6 February 2013

PCU041474

SSD 5356 – Hornsby Ku-ring-gai Hospital Redevelopment Stage 1

Project: PLAN SHOWING DETAIL OVER HORNSBY KU-RING-GAI HOSPITAL CORNER DERBY ROAD AND BURDETT STREET, HORNSBY

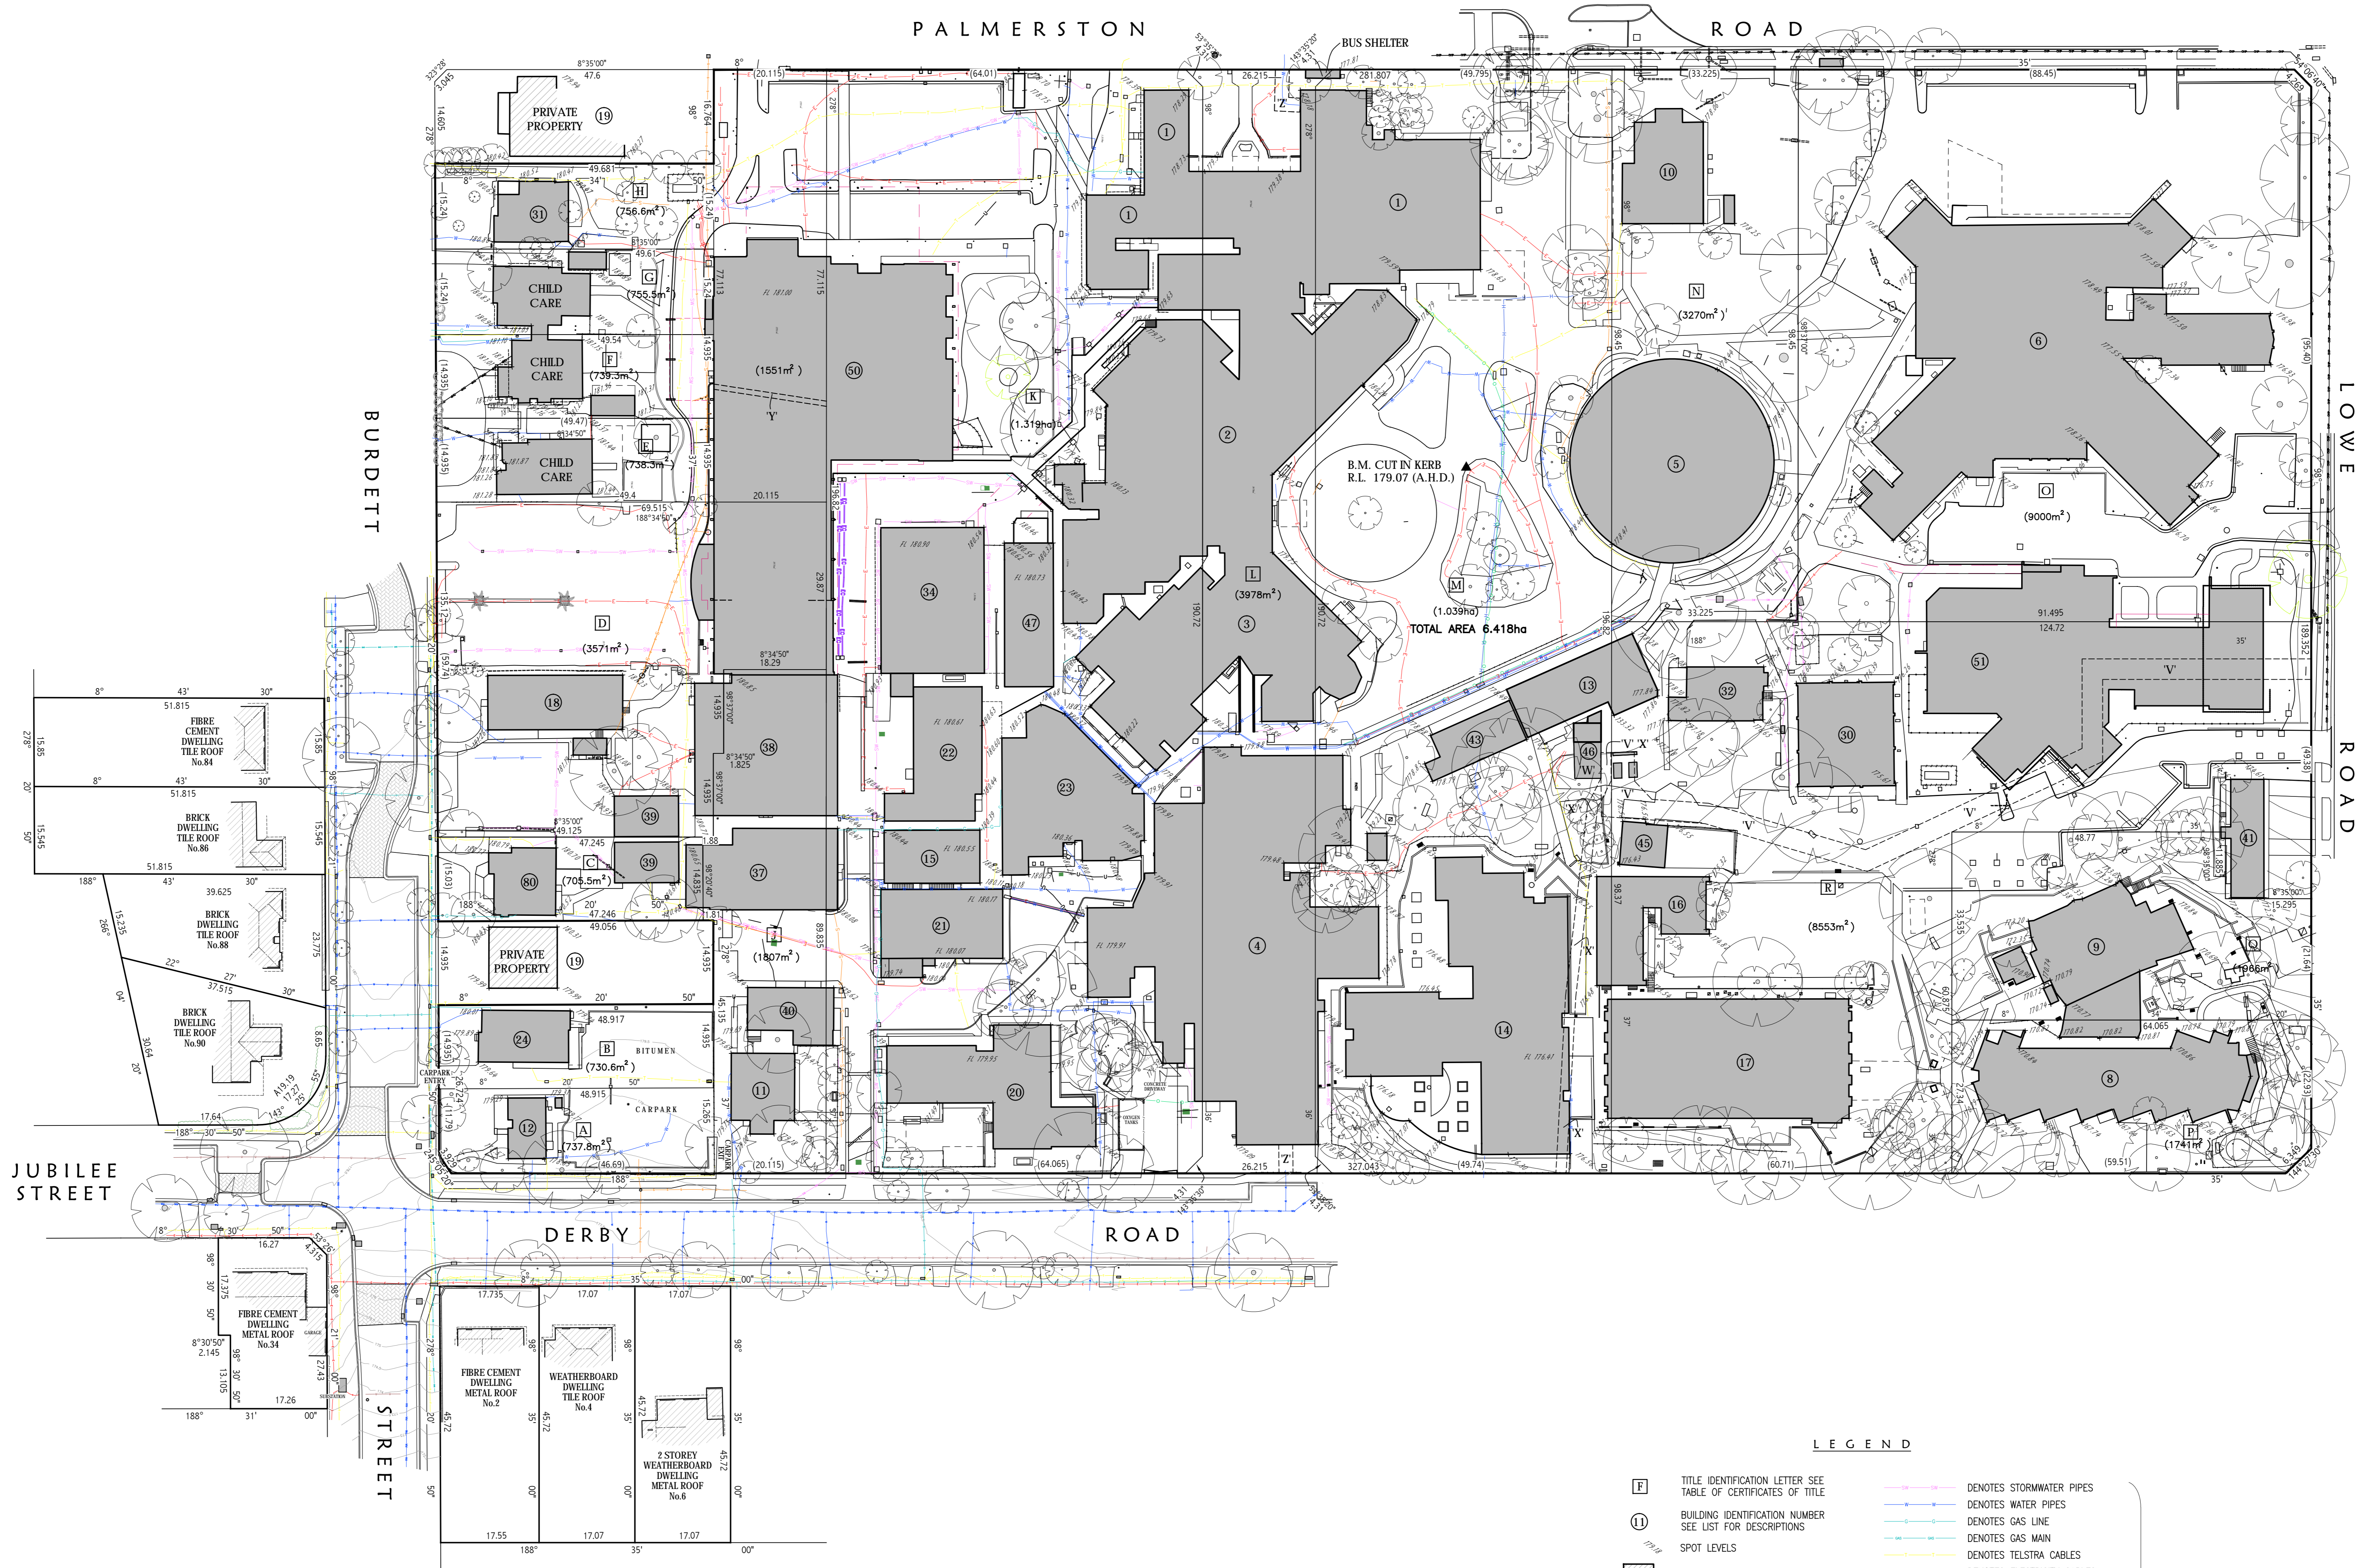
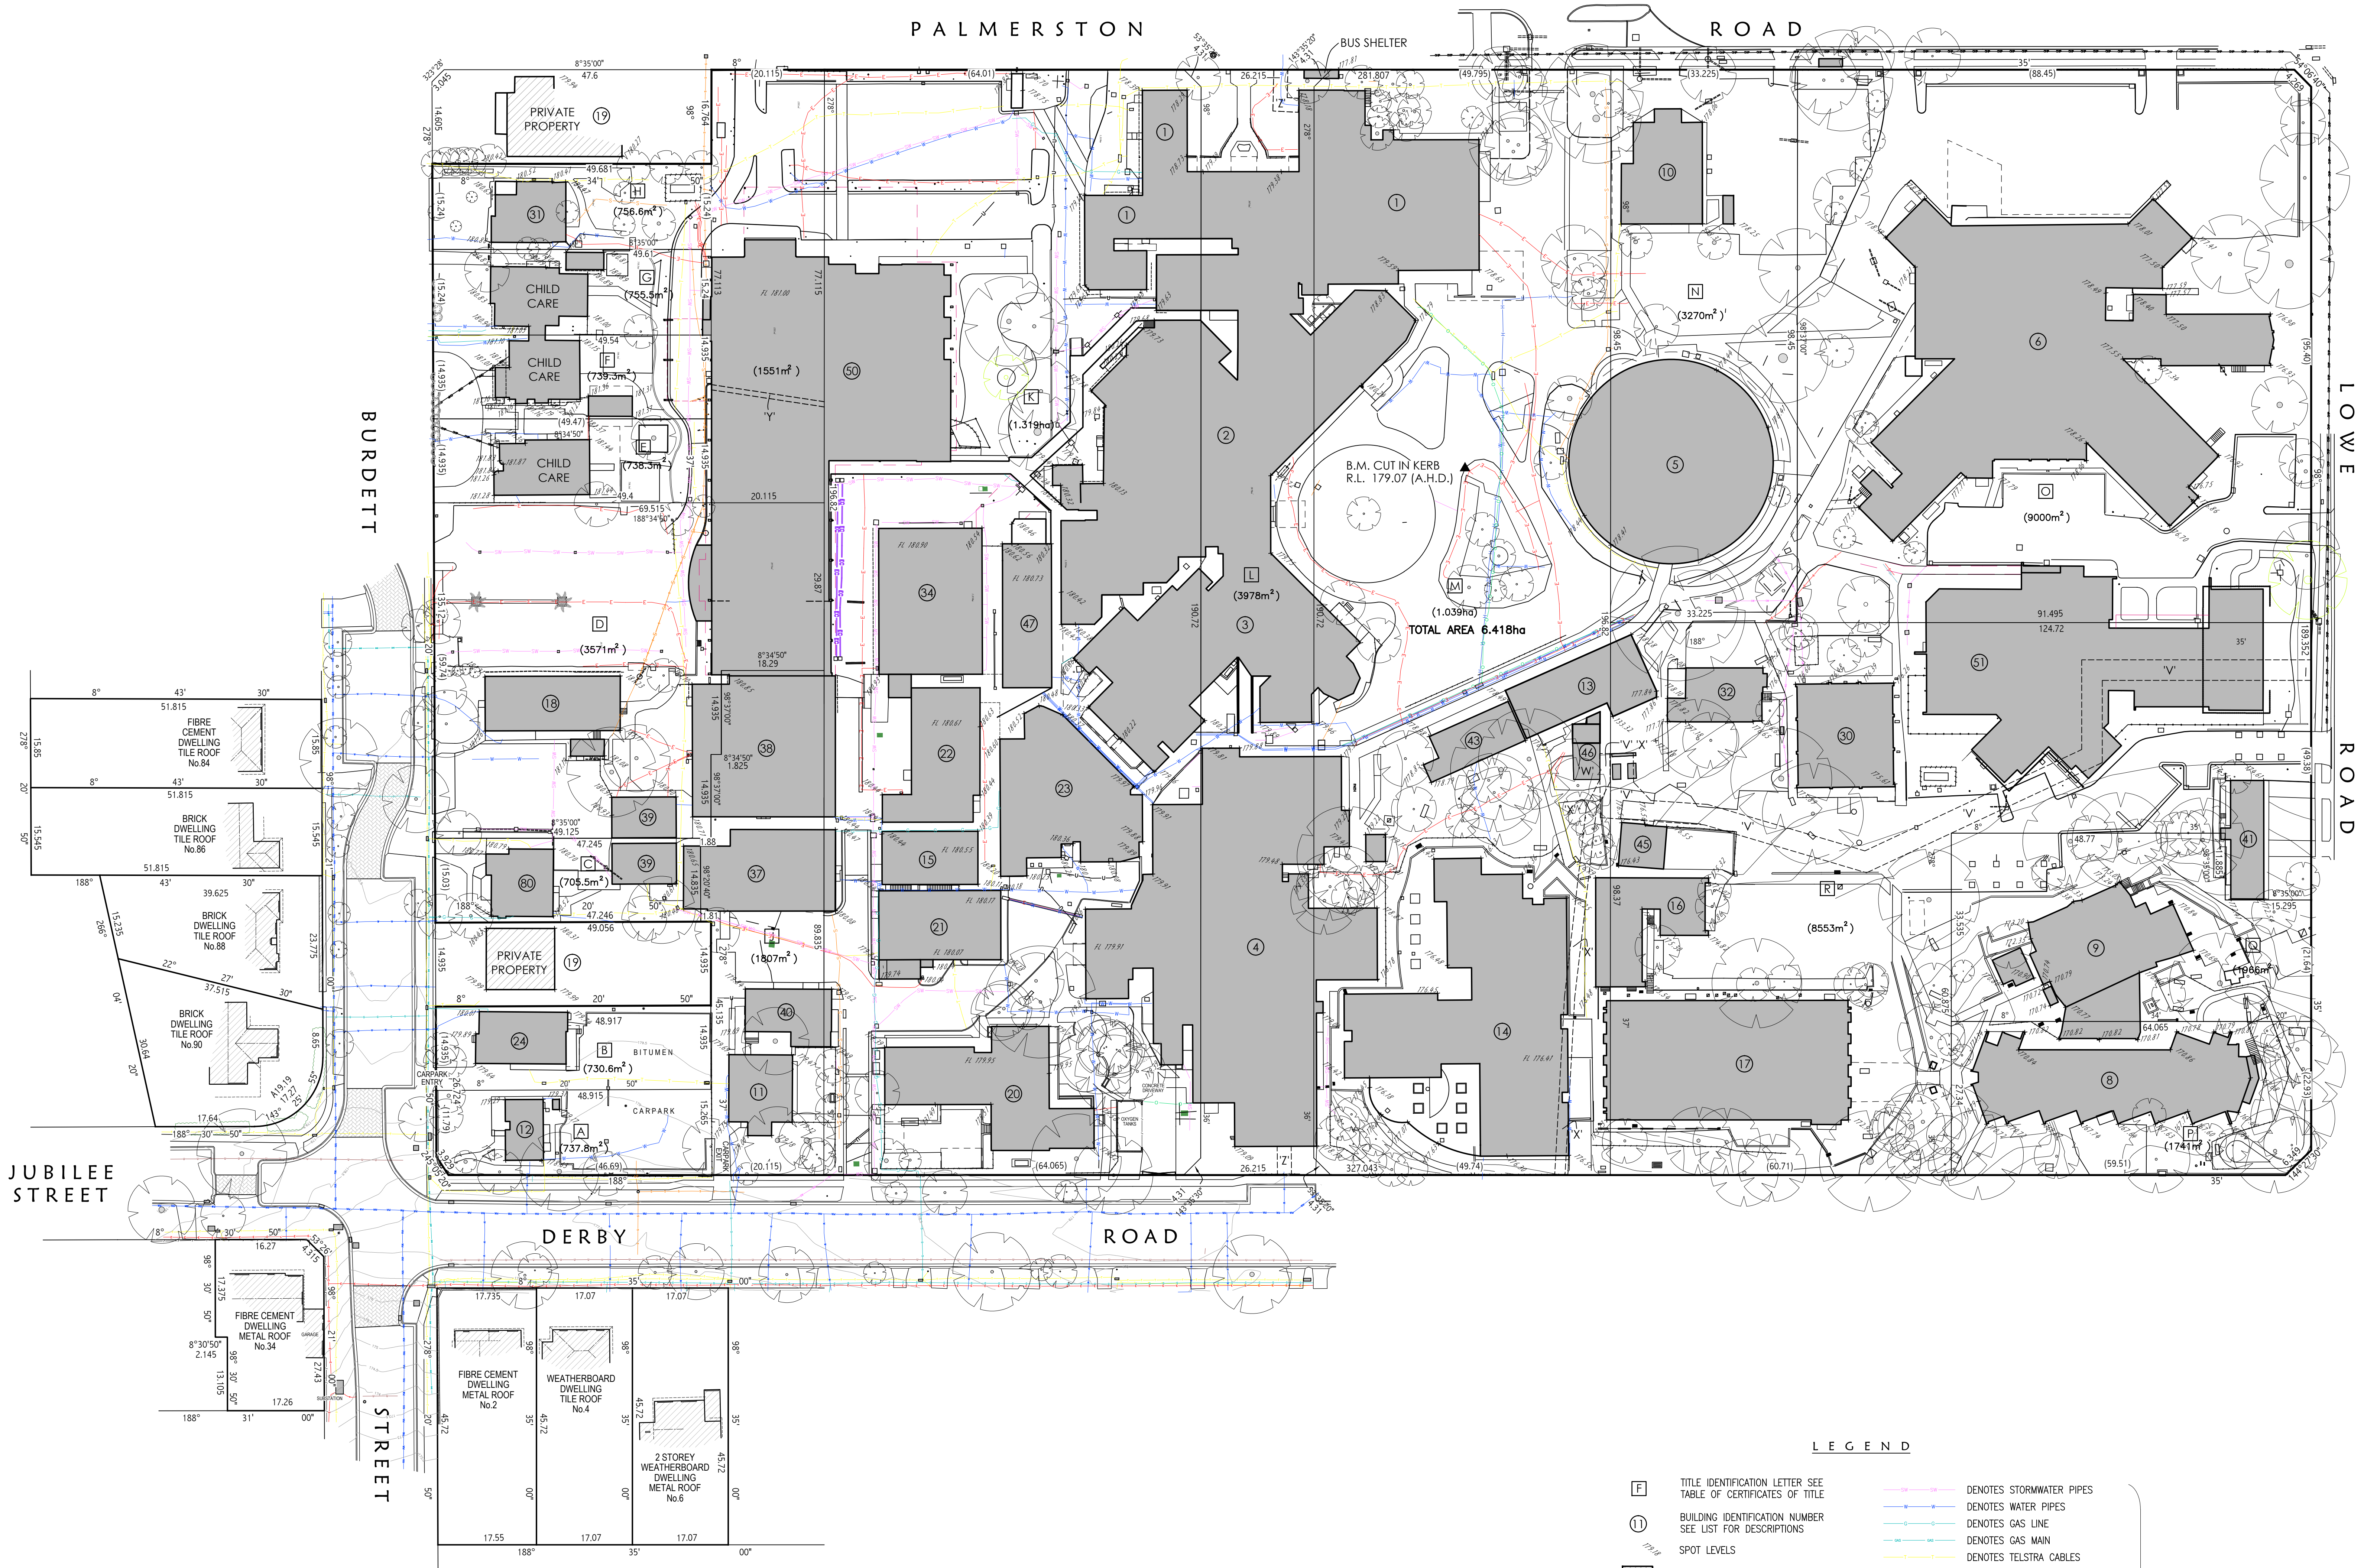
The redevelopment site is traversed by a 150mm wastewater main. It has been noted that the developer propose to make this main redundant upon construction of replacement mains. The proponent should ensure:

1. Lot 23 DP 814181, Lot B DP 363790, Lot 2, 3 & 4 DP 14774 and Lot 1 DP 232290 are consolidated prior to the existing 150mm wastewater main being made redundant.
2. All maintenance holes have unrestricted access, a 1 meter clearance from the outer edge and a 2.4m headroom clearance above the maintenance hole surface level.
3. The disused wastewater main is to be either cut up under the supervision of a Sydney Water Developer Works Inspector (DWI) or be sand filled.
4. Detailed designs are submitted to Sydney Water through the WSC for approval and all wastewater design plans comply with Sewerage Code WSA-02 (Sydney Water Edition).
